From: Martyn White
Sent: 29 October 2021 15:10
To: Maria Tomalova
Subject: RE: AB/102/21/DOC

From: Maria Tomalova [REDACTED]
Sent: 19 October 2021 13:35
To: Martyn White <Martyn.White@arun.gov.uk>
Subject: AB/102/21/DOC

PROPOSED FIRST FLOOR PLAN (1:50)

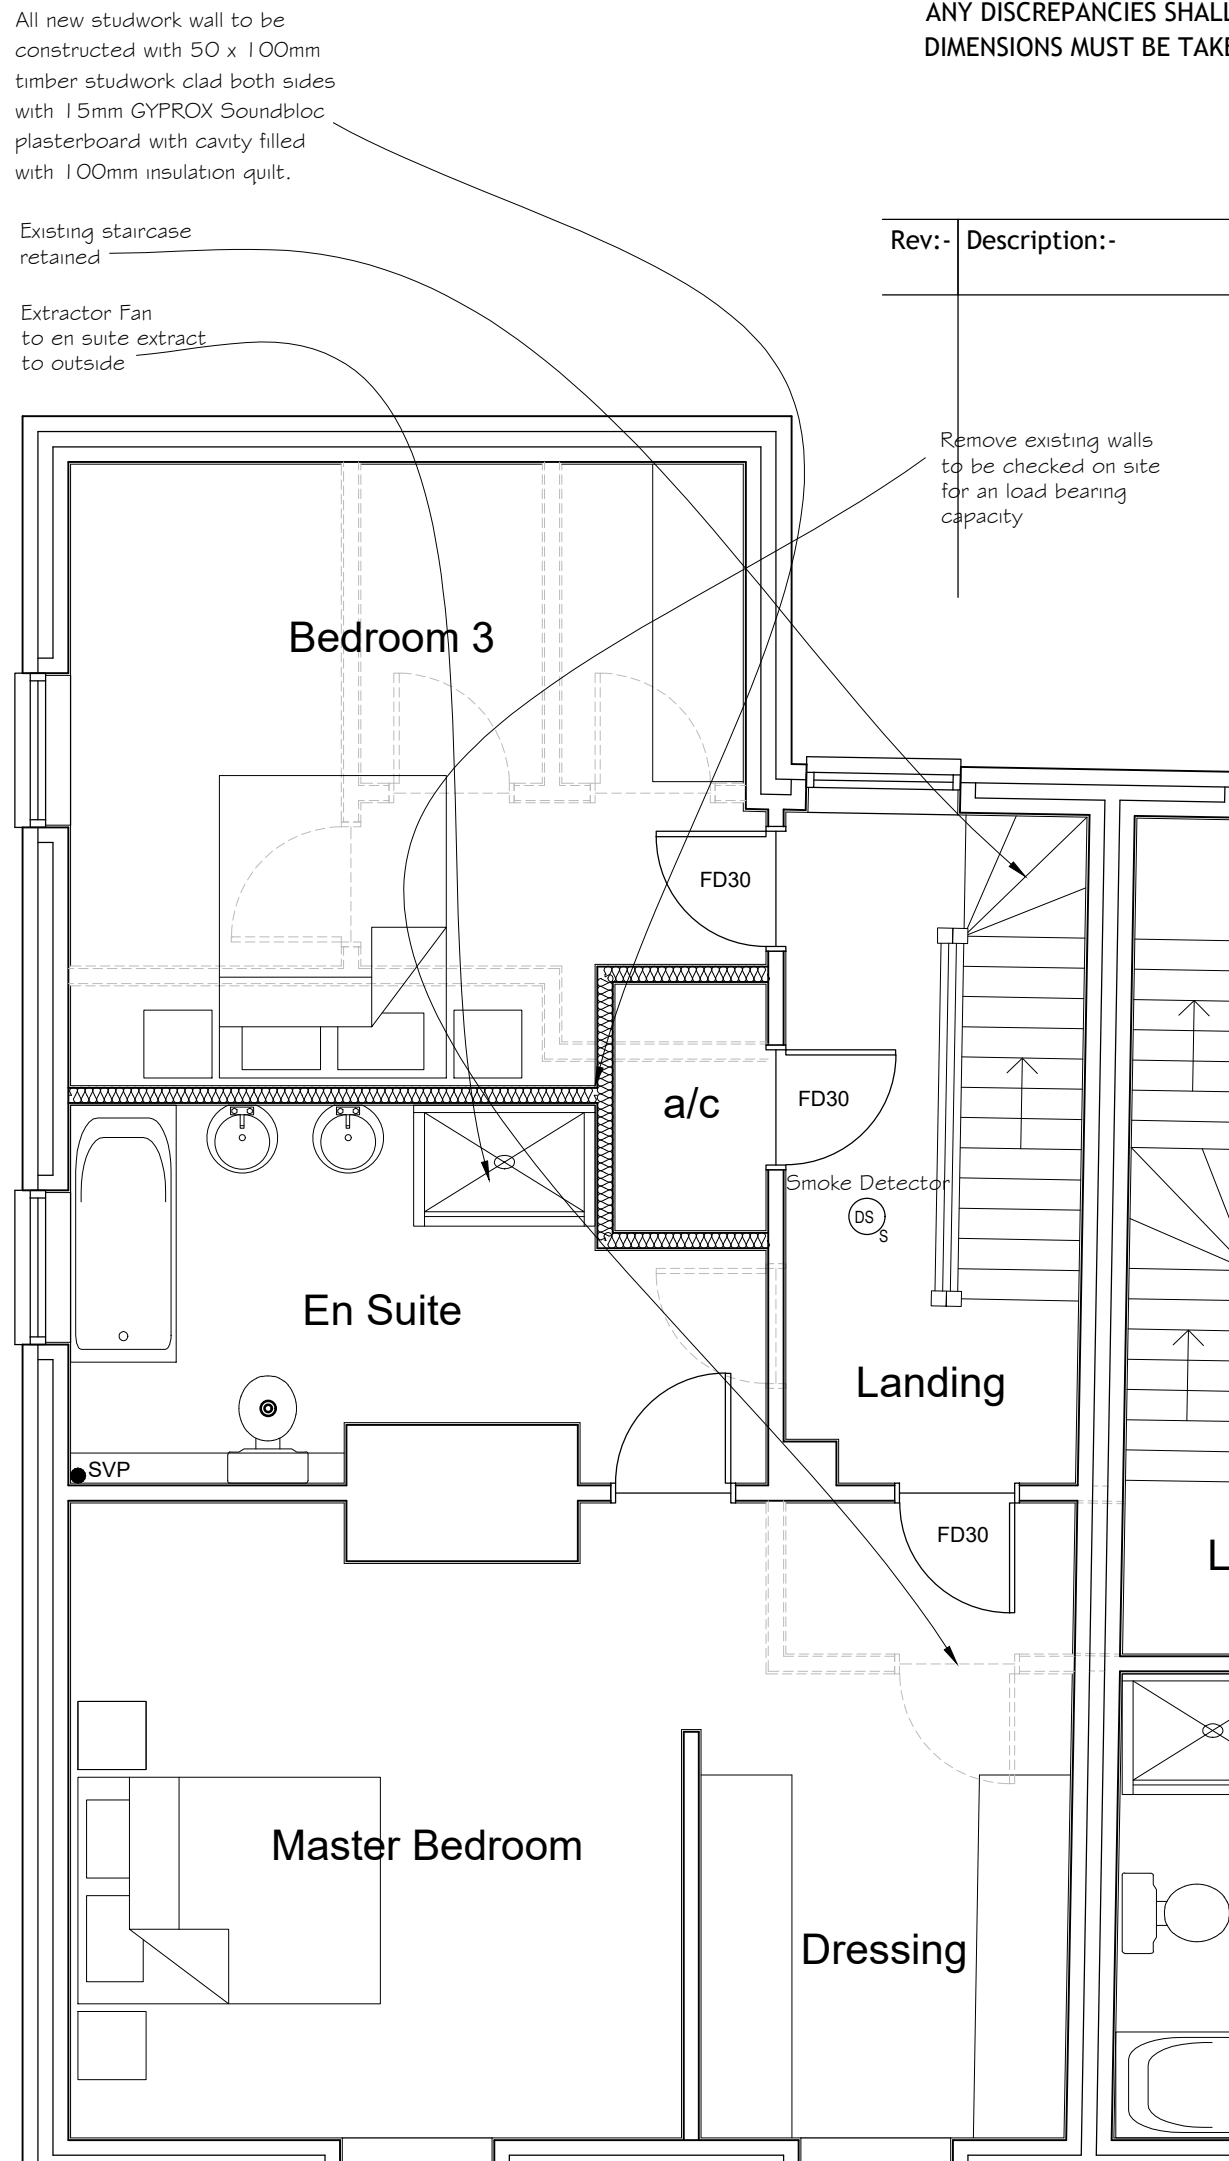
The air vent seems to be acceptable

I am sure that the doors will be ok, especially if they fit the existing openings and that they will be painted to as to look appropriate for the age and character of the building

'We would like to use a single cast iron conservation air vent. Please see link. <https://www.castironairbricks.co.uk/product/conservation-vent-grille/>

To confirm the existing door openings are in imperial sizes which would be 2 foot 6 inches. These can be purchased from our supplies. We do not intend to alter any of the existing door openings. We can purchase doors to fit. We propose to fit colonial 6 panel fire doors to match the existing front door.'
